**Application no: 22/00959/REM**

**Location:** East Of Last House Adjoining And North Of Berry Hill Road Adderbury

## **Transport Development Control**

Oxfordshire County Council, as the Local Highway Authority, **object** to the approval of this Reserved Matters application.

BERRY HILL ROAD, ADDERBURY - DRAFT SITE LAYOUT

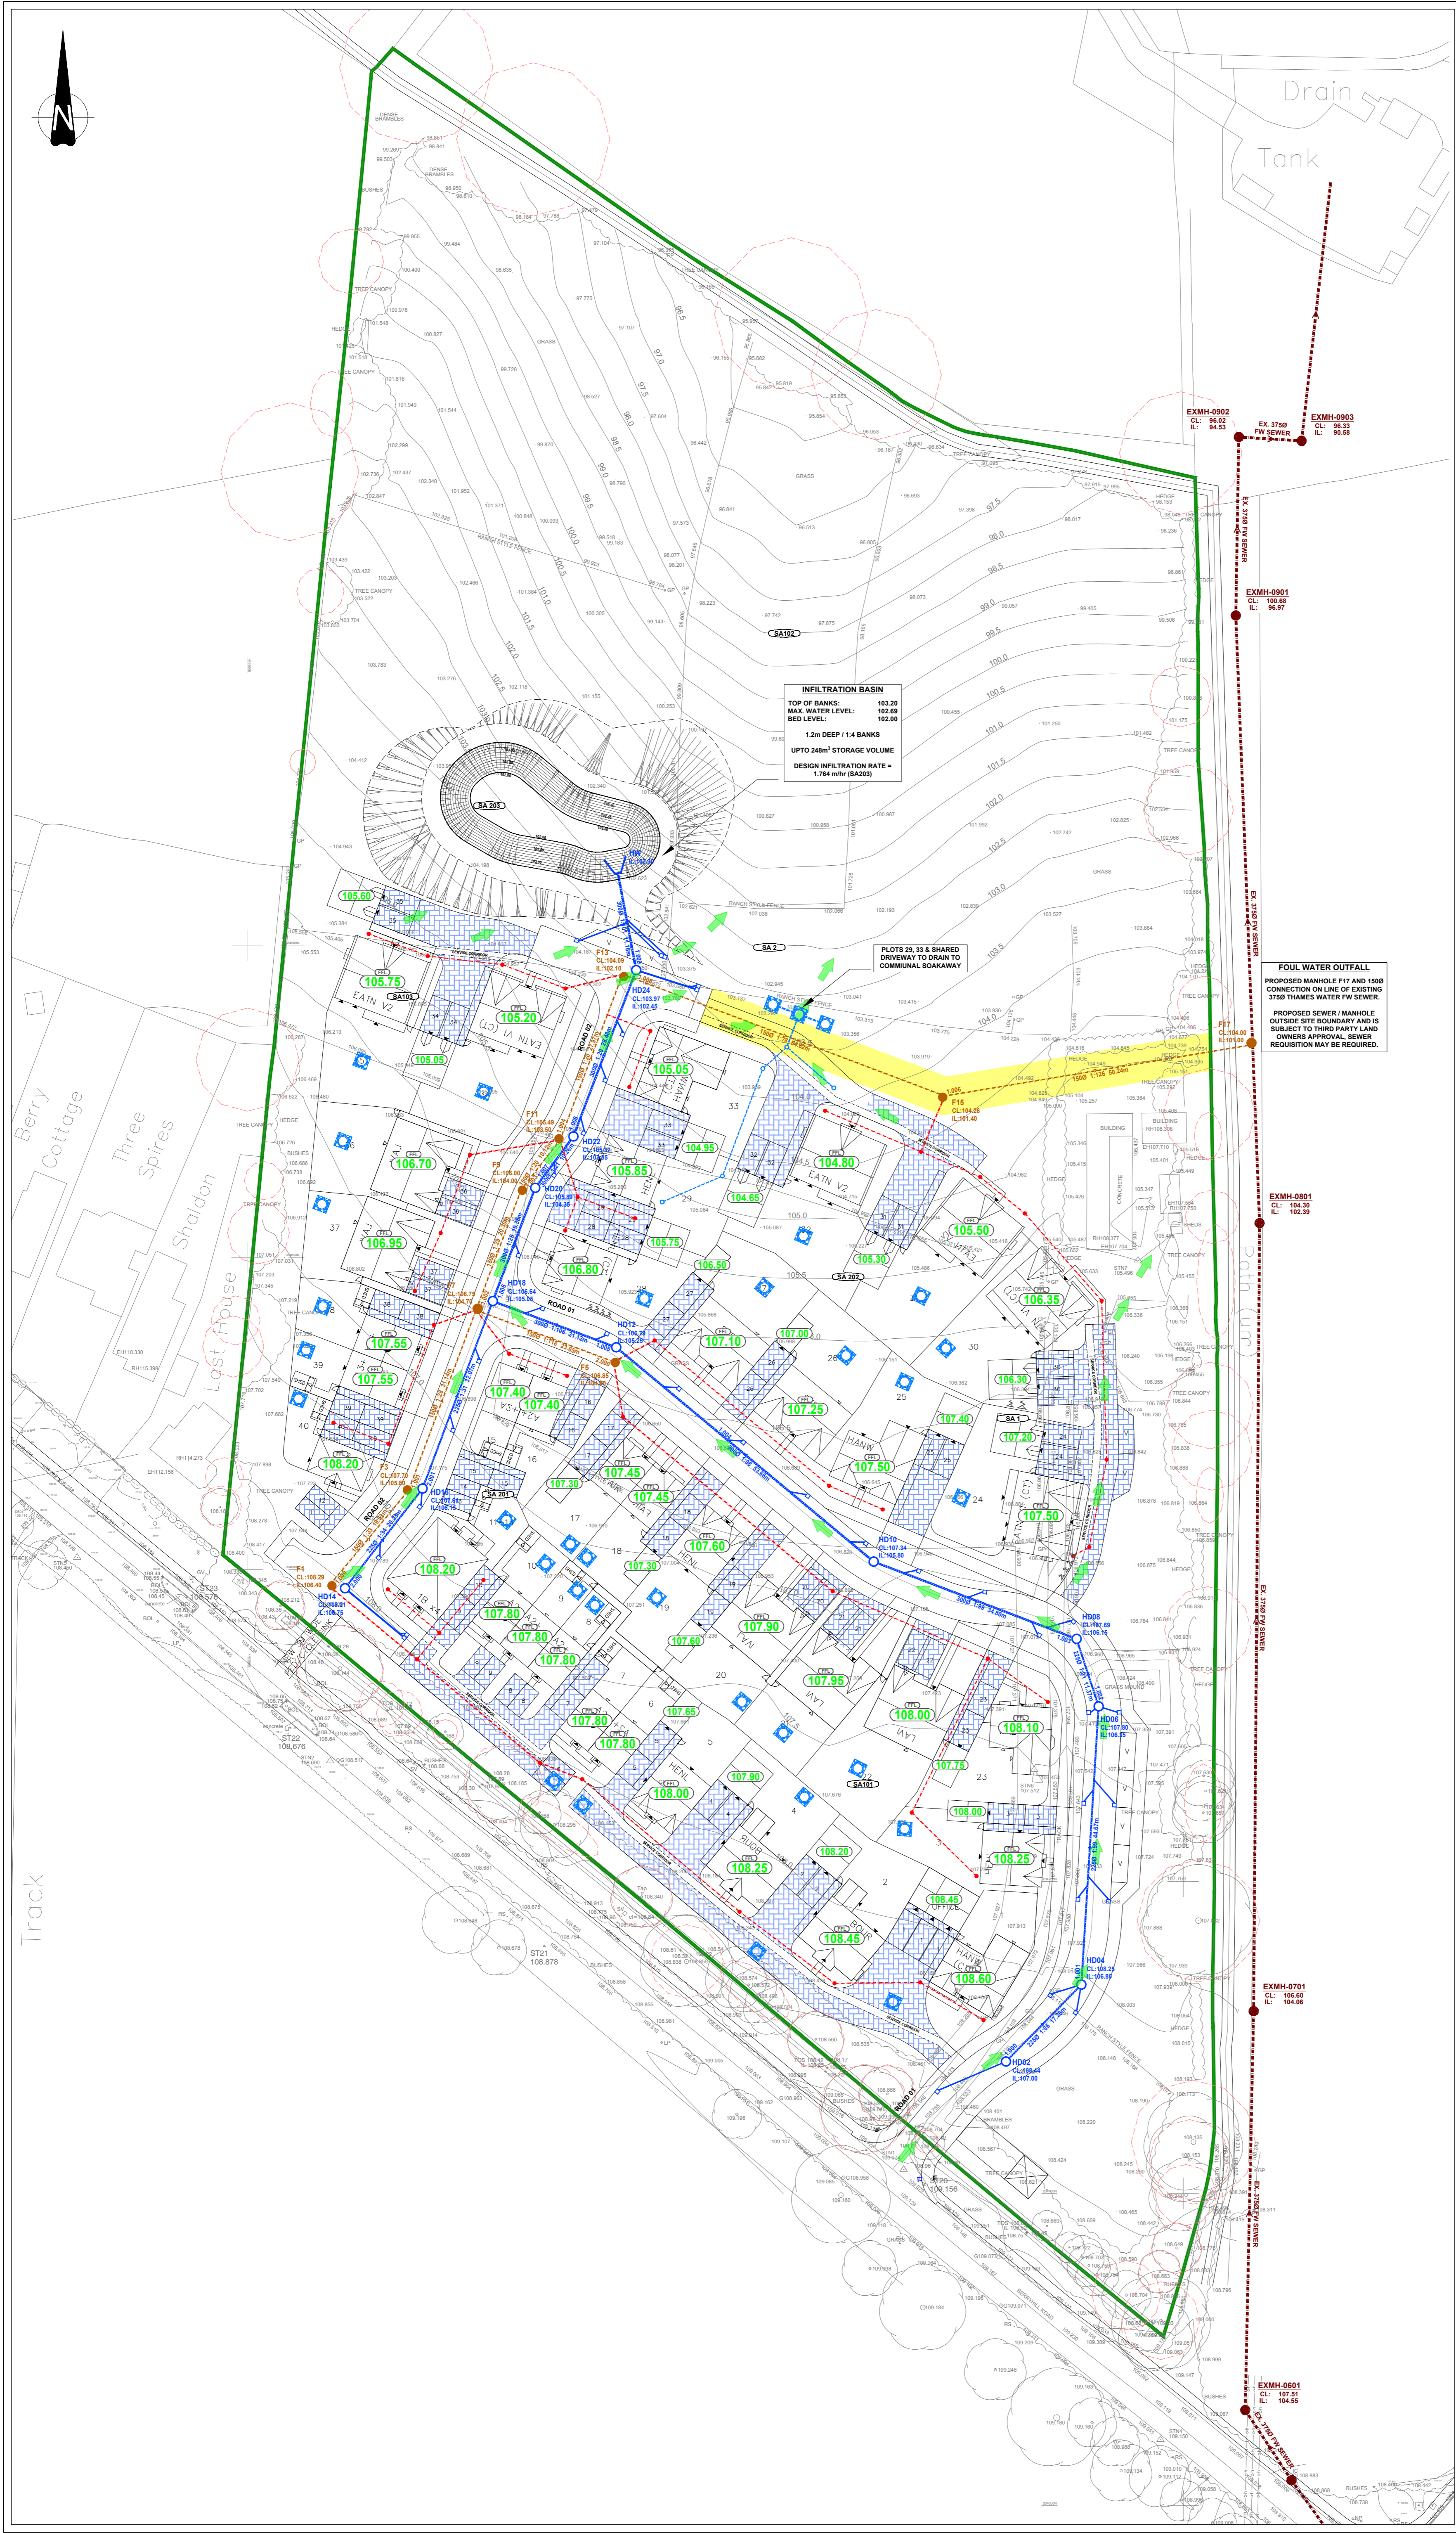
**Landing Spots:** Where the section of 1:20 longitudinal gradient is present there will need to be flat landing spots.

**Swept Path Analysis:** Vehicle length does not match the request from OCC Road Agreements.

Where the section of 1:20 longitudinal gradient is present there will need to be flat landing spots. OCC's inclusive mobility guidance states that 'even if there not a pedestrian route in excess of 1:20, it is important that there are level sections or landings at regular intervals to provide people with an opportunity to rest.' A level landing must be provided for every 500mm that a route rises.

- A section 278 application will be required for the access works.
- Where the section of 1:20 longitudinal gradient is present there will need to be flat landing spots.
- Refuse vehicle should be tracked with 11.6m refuse vehicle and should ideally also not overhang the footway as this provides potential for conflict with pedestrians. The vehicle should also be shown tracking past a stationary car to ensure that the refuse vehicle is able to safely manoeuvre around the sections of road that are 4.8m in width.
